**WELWYN HATFIELD BOROUGH COUNCIL
EXECUTIVE DIRECTOR - PLANNING, PUBLIC PROTECTION AND GOVERNANCE**

DELEGATED APPLICATION

Application No: 6/2018/2225/LB
Location: Oshwal Centre Coopers Lane Road Northaw Potters Bar EN6 4DG
Proposal: Repair and maintenance to walls, floors and timber fixtures, repainting and waxing to match the existing treatments to include installation of wainscoting in bridge rooms, reinstatement of existing doorways
Officer: Mr William Myers

Recommendation: Granted

6842-76-P1

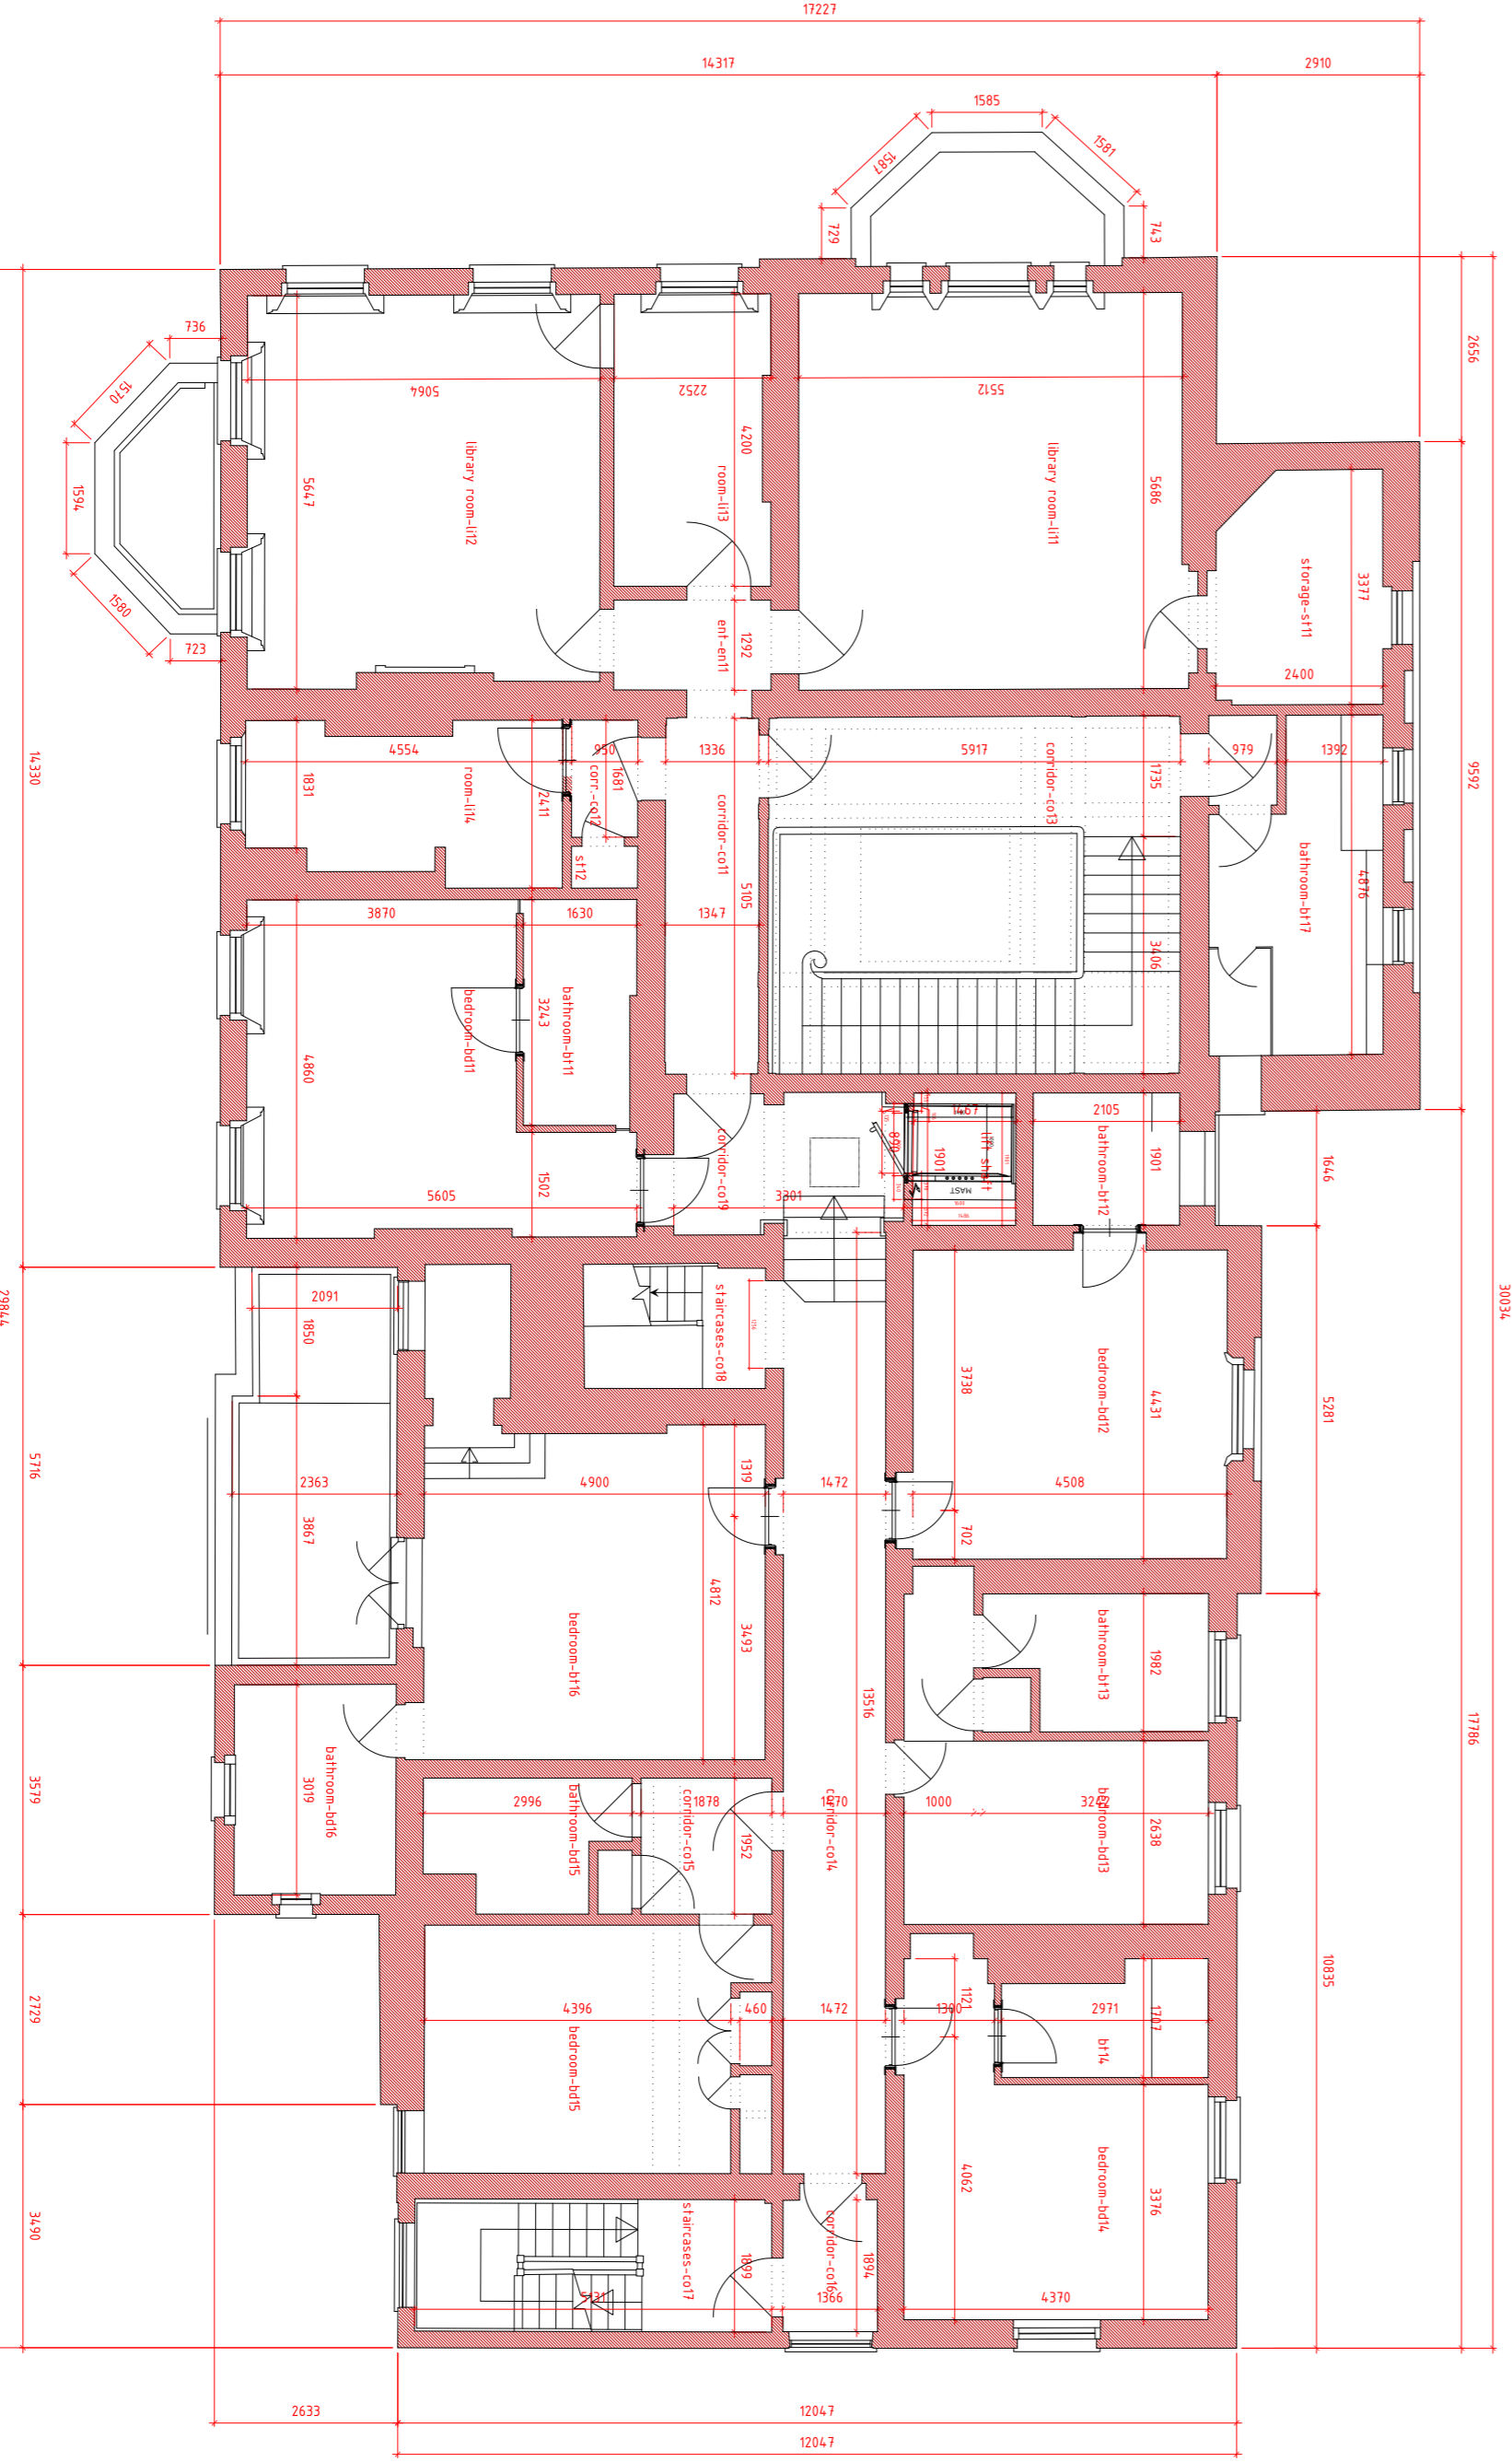
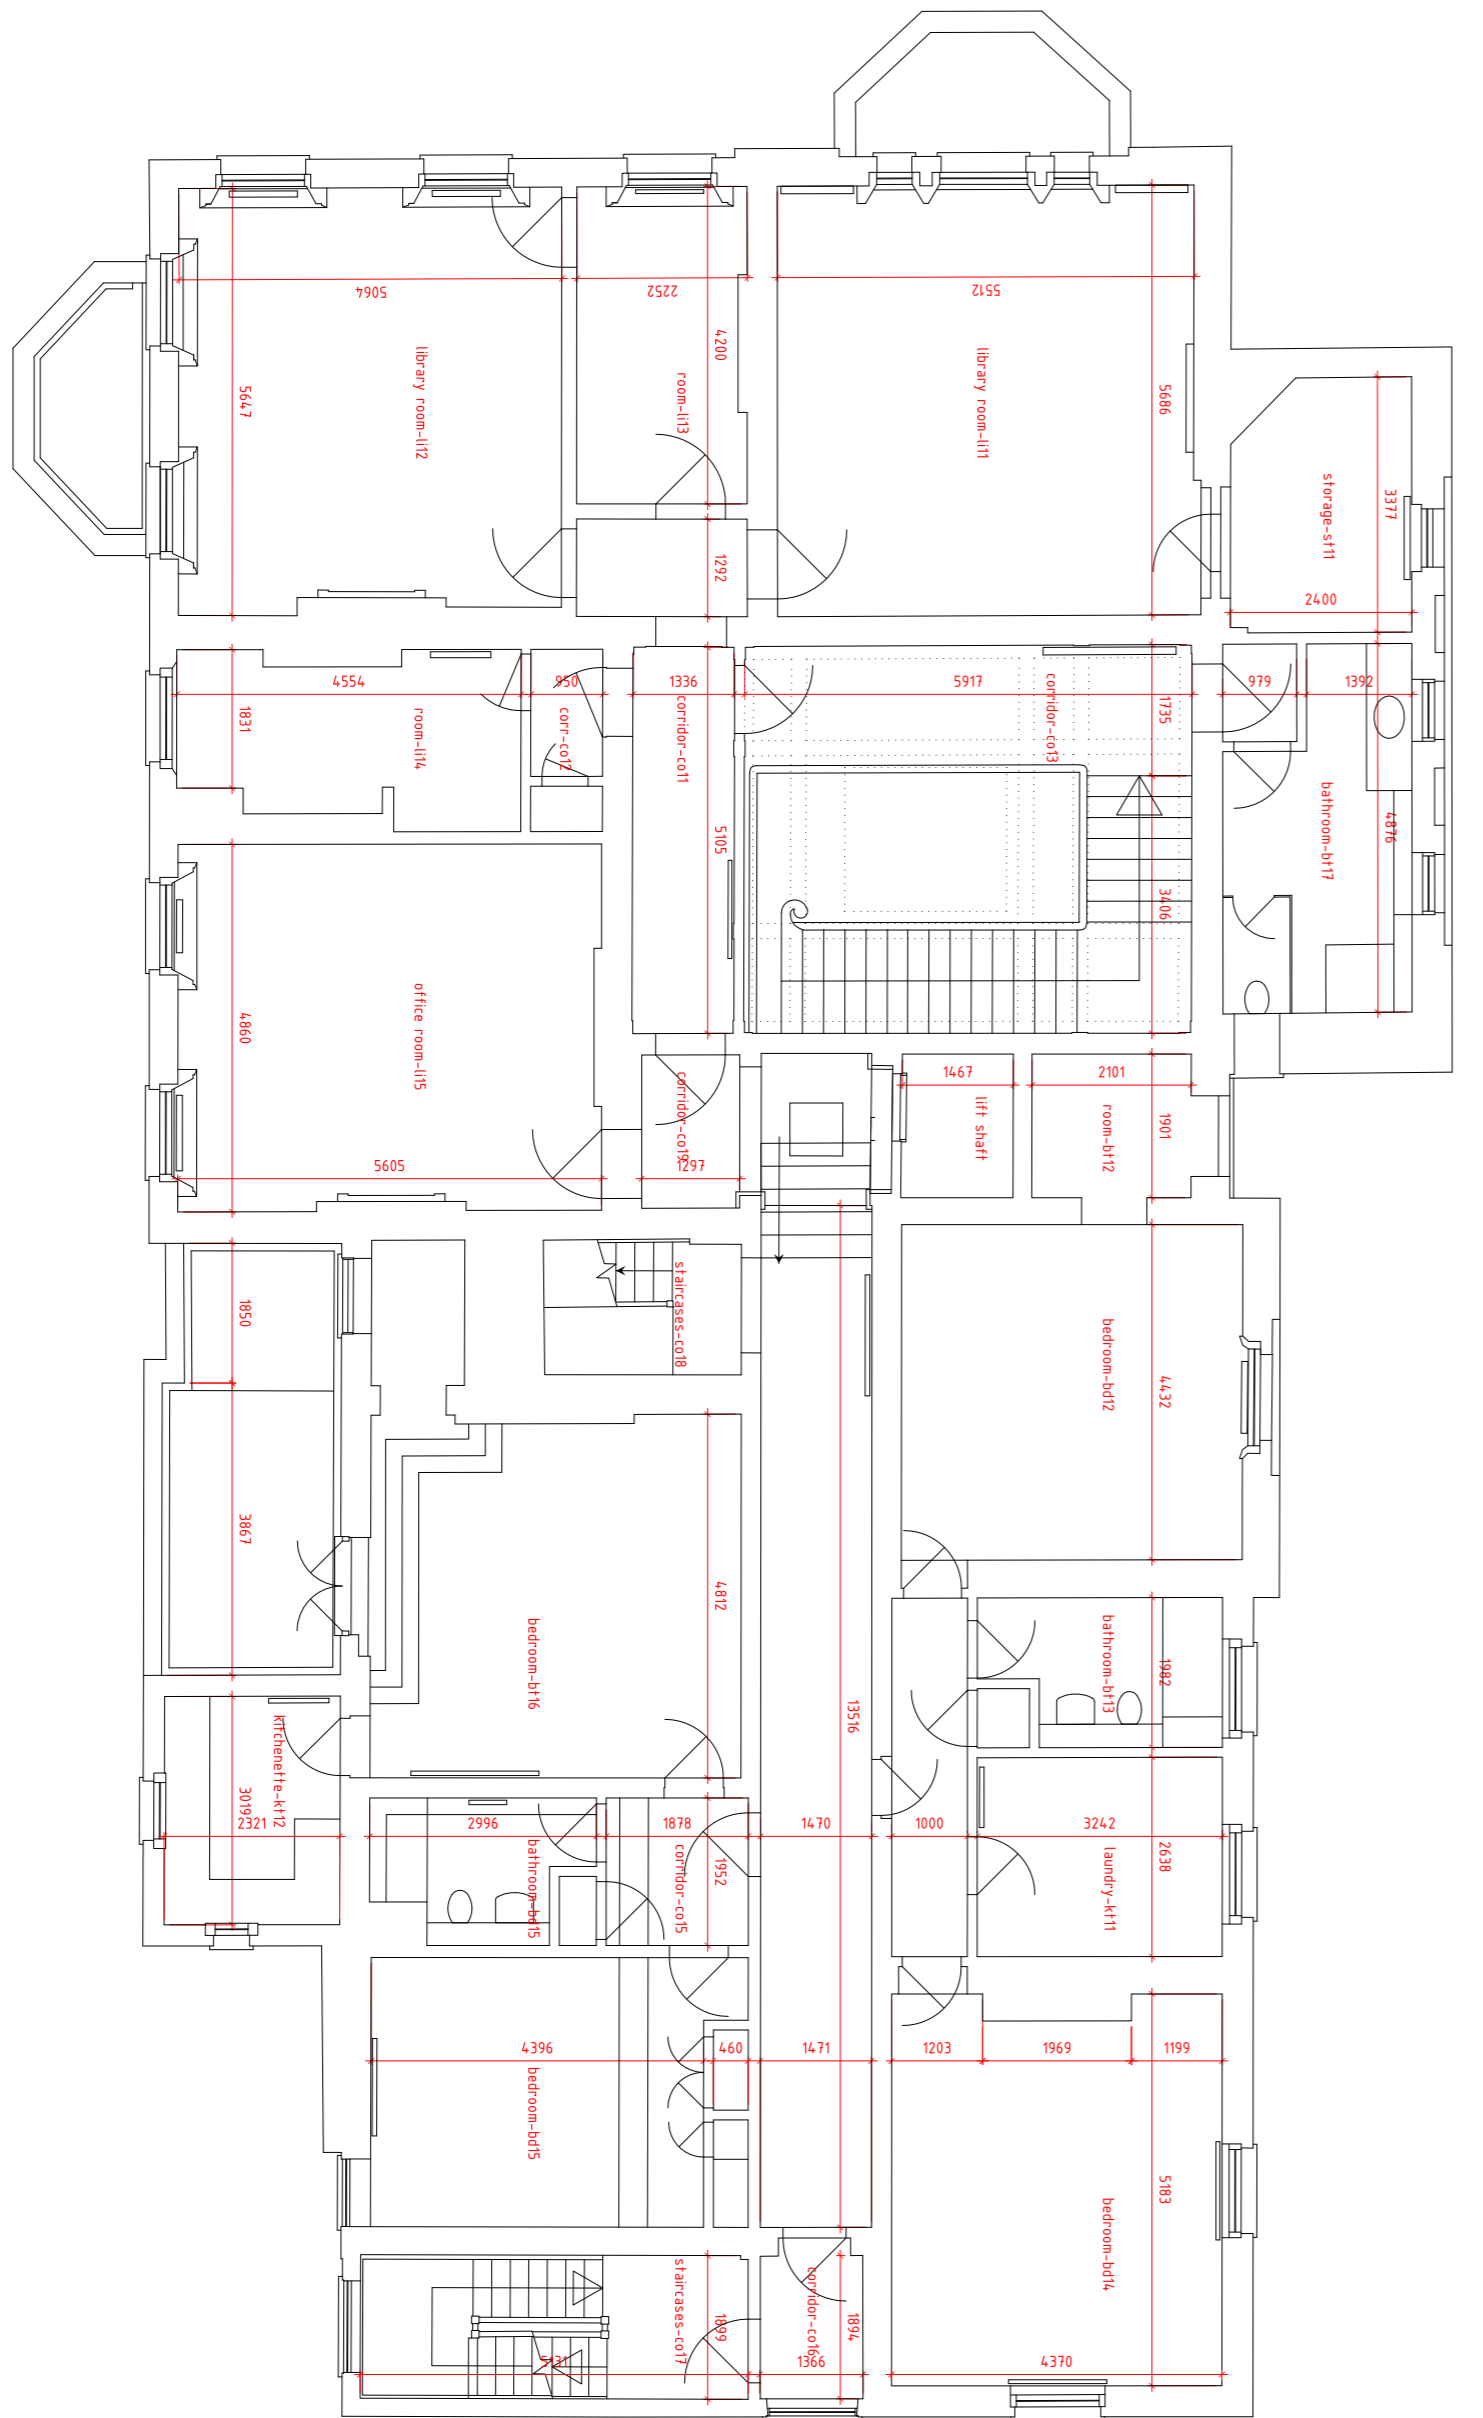
<p>The proposed alterations are considered to be acceptable as they do not cause undue harm to the overall significance of the listed building. The highest degree of change is confined to the later 19th century section of the house on the first floor, predominantly in areas where alterations and additions have already been made in the mid-late 20th century. The most significant rooms on the ground floor (and their fixtures and fittings) remain unchanged and the first floor plan remains legible. The insertion of the en-suite 'pod' in room 28 curtails the volume of this original room. However, subject to a condition requiring that additional information is provided which would detail how the proposed glazing would attach to the existing walls, it is considered that on balance, the proposed 'pod' would be acceptable given the long-term use of the building, the reversibility of the intervention, and the glazing detail to the edges which provides a lighter touch and proposes to allow the original proportion of the room to be understood.</p> <p>The faux stone wainscoting to the ground floor bridge rooms is a somewhat incongruous feature given the historic timber panelling in other rooms, however, the submitted drawings have demonstrated that it would not interfere with any historic features and is a reversible addition, although more permanent in appearance than other forms of decoration (painting or wallpaper for example). It does, however, have some benefit in protecting the lower part of the walls in these heavily used rooms. Furthermore, it is considered that in the interest of preserving the historic fabric of the features behind the proposed wainscoting that it would be reasonable and appropriate to impose a condition on any approval that would require that none of the new wainscoting panels, or batons supporting them, shall be affixed to the skirting boards. Subject to this condition being imposed, it is considered that these proposed works would be acceptable.</p>

1. Prior to the installation of the en-suite bathroom, details of the junction between the new en-suite bathroom walls and existing walls in room 28, drawn at a scale between 1:1 and 1:20 as appropriate, must be submitted to and approved in writing by the Local Planning Authority. Subsequently the development must not be carried out other than in accordance with the approved details.

2. The wainscoting panels, or batons supporting them, must not be affixed to the skirting boards unless otherwise agreed in writing with the Local Planning Authority.
